CITY OF ALBUQUERQUE

RE: La Cueva Gym - 7801 Wilshire Ave NE, BP-2016-01346
Engineer's Stamp Date: 5/23/2016 - Certification Date 2/12/2018
Release of Temp CO - Hydrology File: C19D004 - Approved

SHEET TITLE
GRADING PLAN
WEIGHT ROOM ADDITION

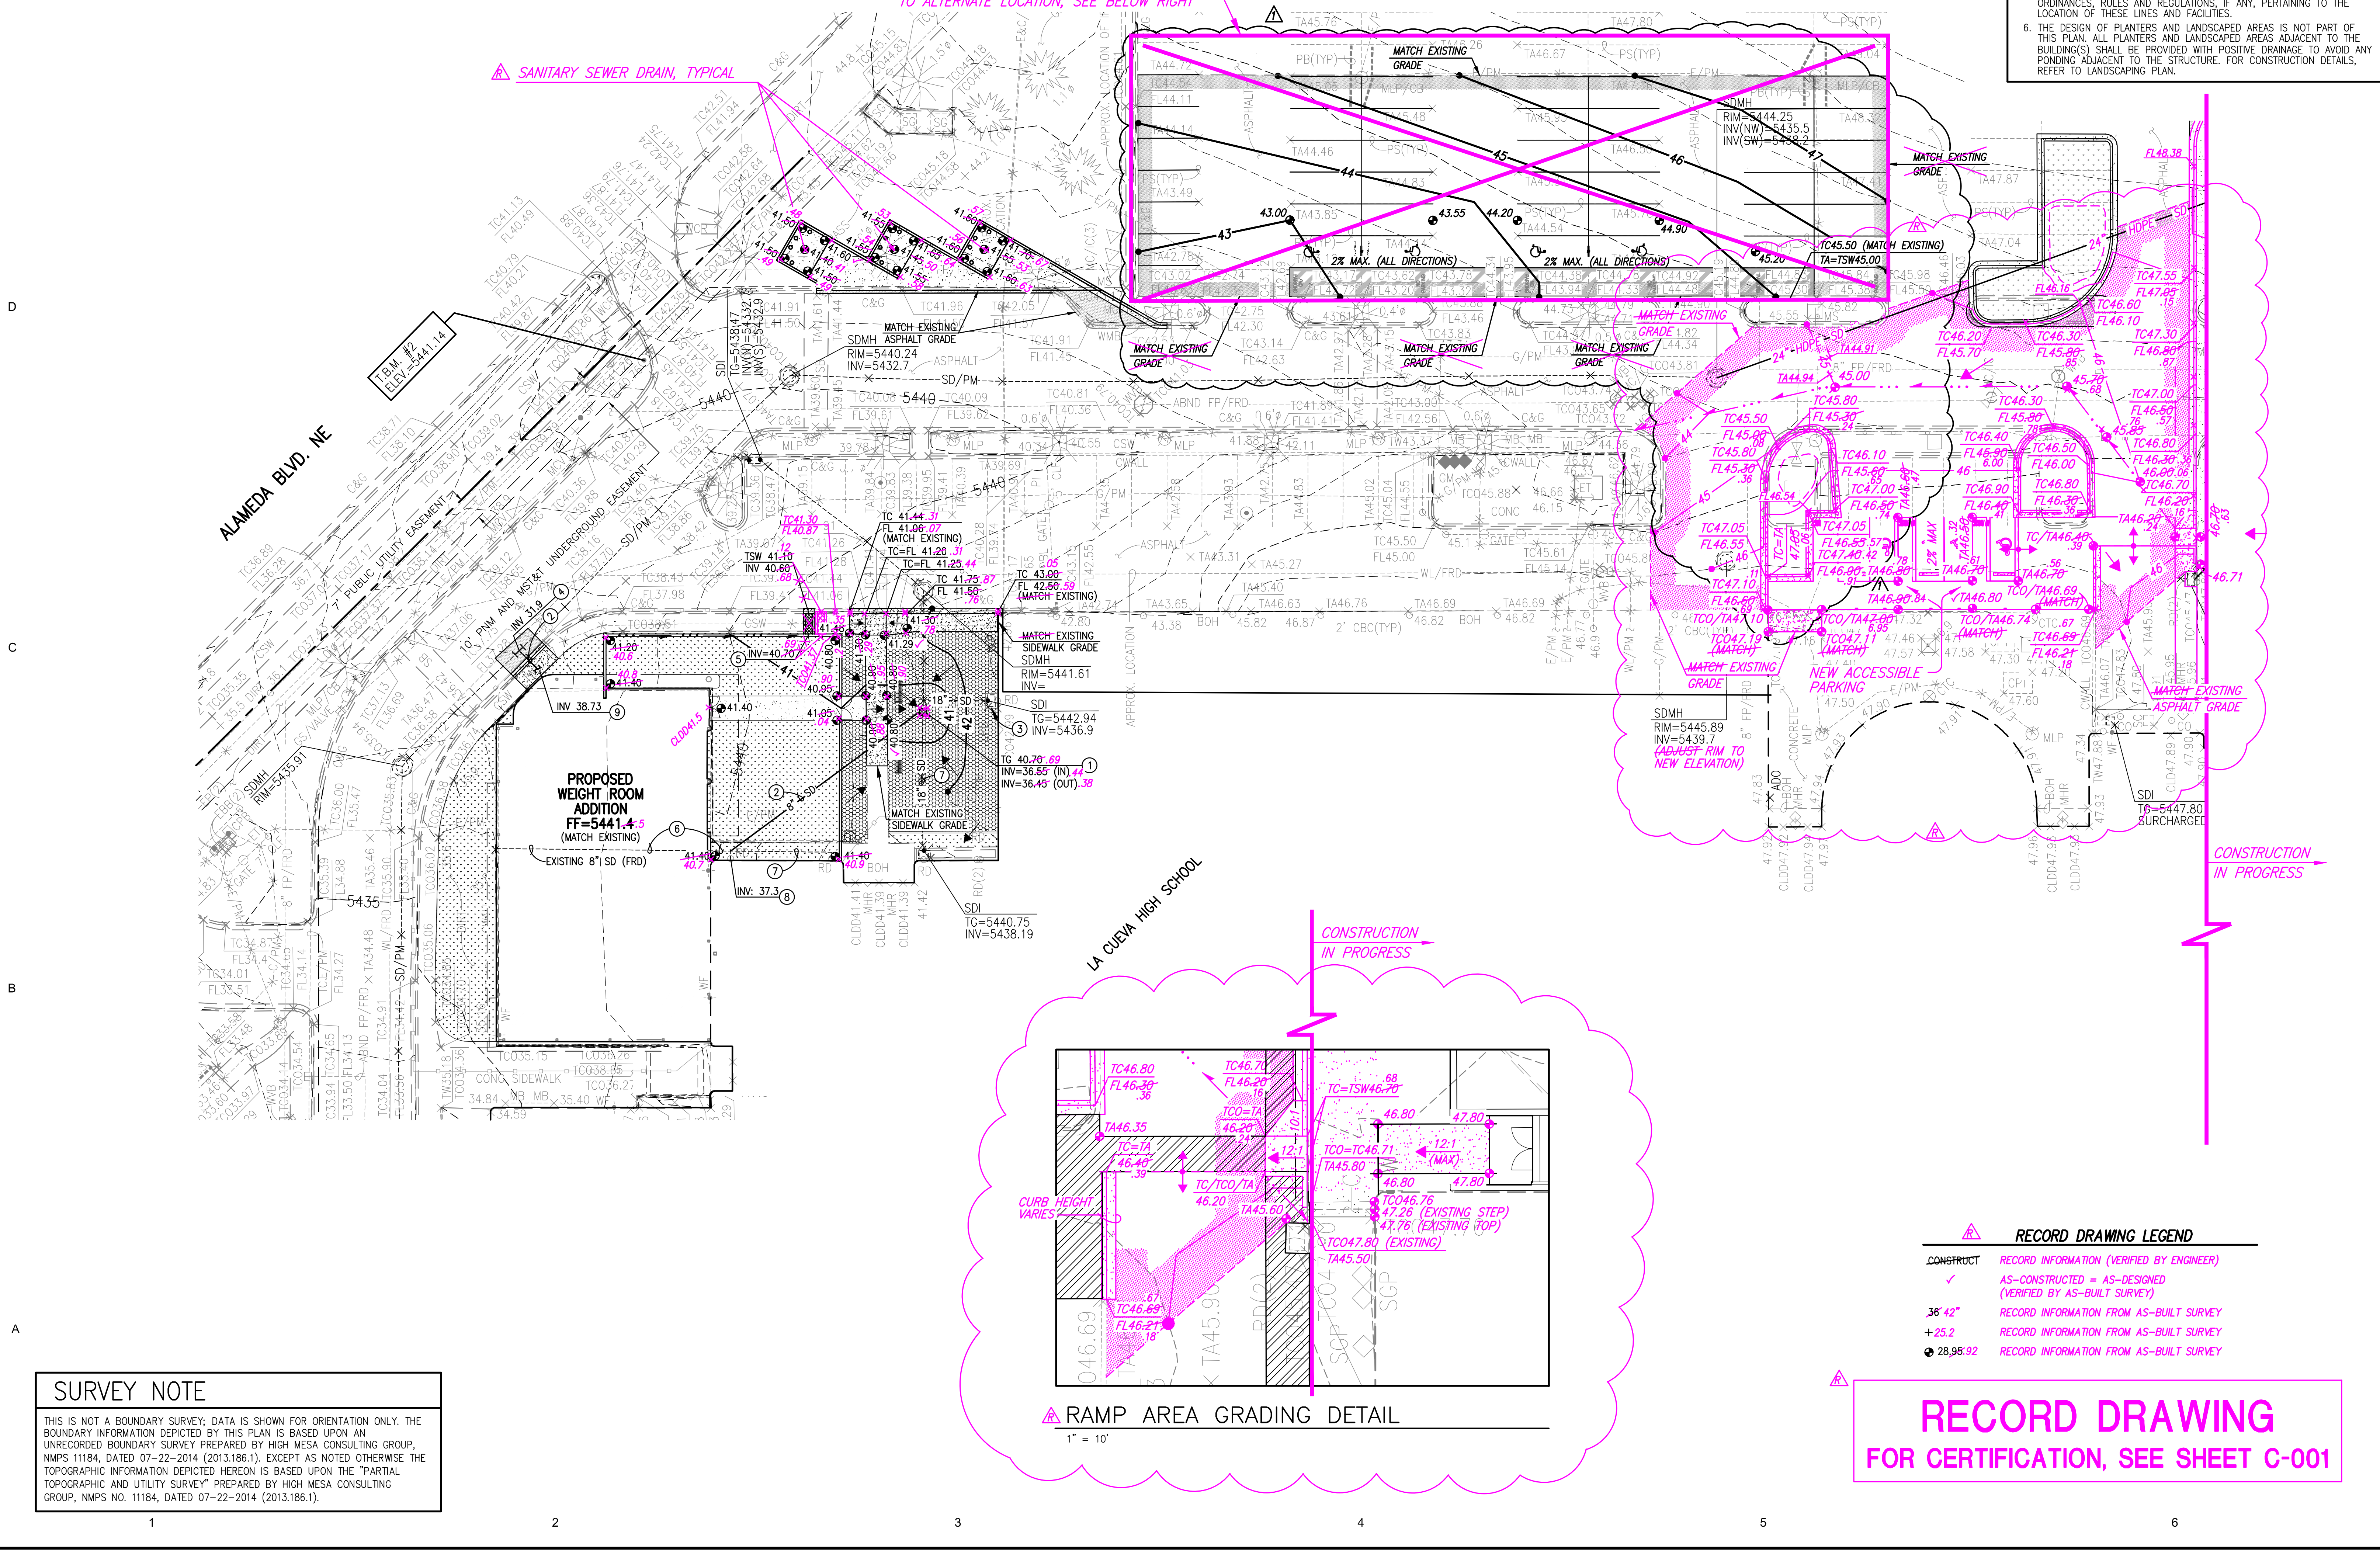
Prior to final Certificate of Occupancy the Site must be stabilized. The landscaping was missing when on 2/15/2018.
